# CITY OF ALBUQUERQUE

June 16, 2017

**Re: GAHP Casa Feliz  
421 Espanola Street SE  
Requested for Permanent C. O. – Not Accepted  
Engineers Stamp Date 12/18/15 (L19D073F)  
Certification dated: 6-7-17**

**RIP-RAP CHANNEL SECTION B-B**  
NOT TO SCALE

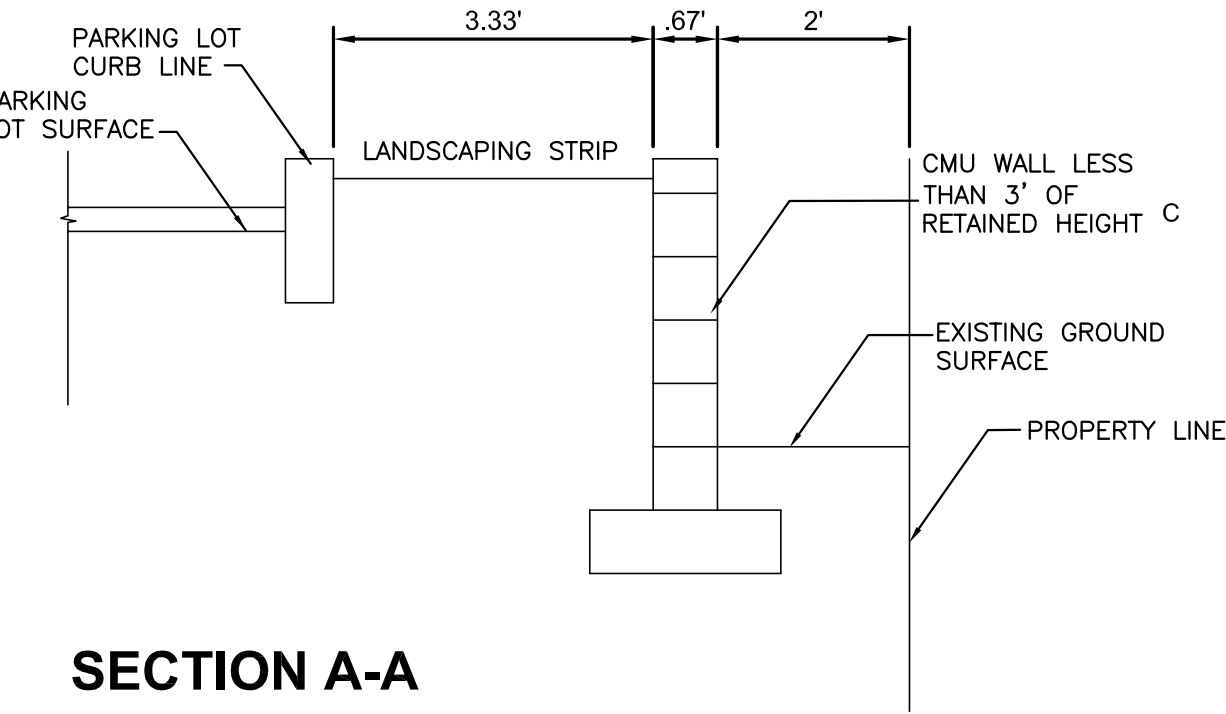
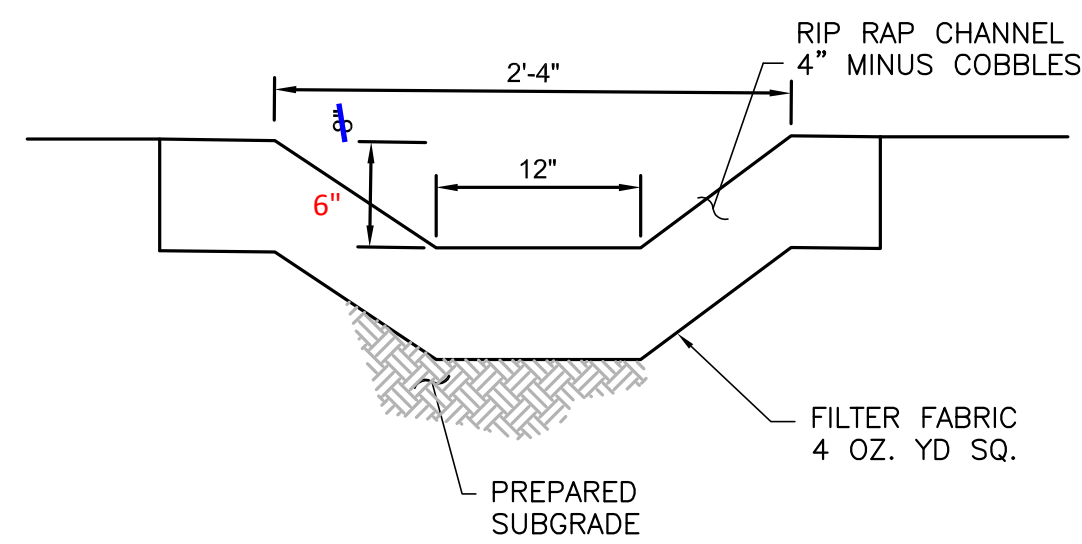
- Your certification states that the site is constructed according to the approved plan however it was not. Please show the culvert that replaced channel, section B-B, and certify the culvert is adequate to convey 100-year flows without any cross-lot drainage on to the neighboring lot.
